An
Bord
Pleanála

Board Direction
BD-005437-20
ABP-306075-19

The submissions on this file and the Inspector's report were considered at a Board meeting held on 19/03/2020.

The Board decided to grant permission generally in accordance with the Inspector's recommendation, for the following reasons and considerations, and subject to the following conditions.

| GROUND FLOOR PLAN | JOB NO: 14030.7 | DRAWING NO: PL06 |

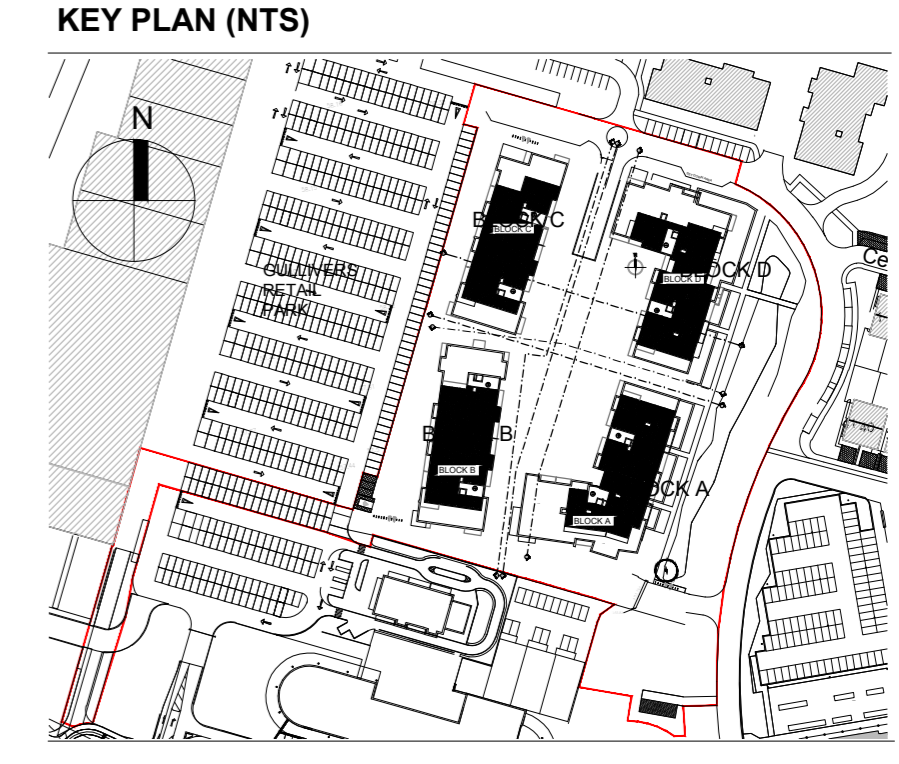
(i) An increase in the area of the proposed childcare facility, including outdoor play provision, to accommodate a minimum of 62 childcare places. This shall be achieved by internal modification and omission of two Block C ground floor apartment units (Units C2/2 and C2/1) as shown in Drwg PL06

(ii) All ground floor courtyard courtyard facing windows shall be increased to a minimum floor-to-ceiling height of 2.7 metres

(iii) Details of privacy screens and buffer strips, which shall be provided between balconies at ground floor levels and above

(iv) Details of changing/toilet facilities to be provided in close proximity to the ancillary residential facilities/services on the ground floor of Block A

(v) Details of proposed vents, flues and rainwater goods within the central courtyard area. The proposed vents shall be redesigned so as to be less visually prominent with other forms of venting examined; shall be located in a less visually prominent location and/or shall be redesigned through the use of creative solutions

Revised drawings showing compliance with these requirements shall be submitted to, and agreed in writing with, the planning authority/An Bord Pleanála prior to commencement of development.
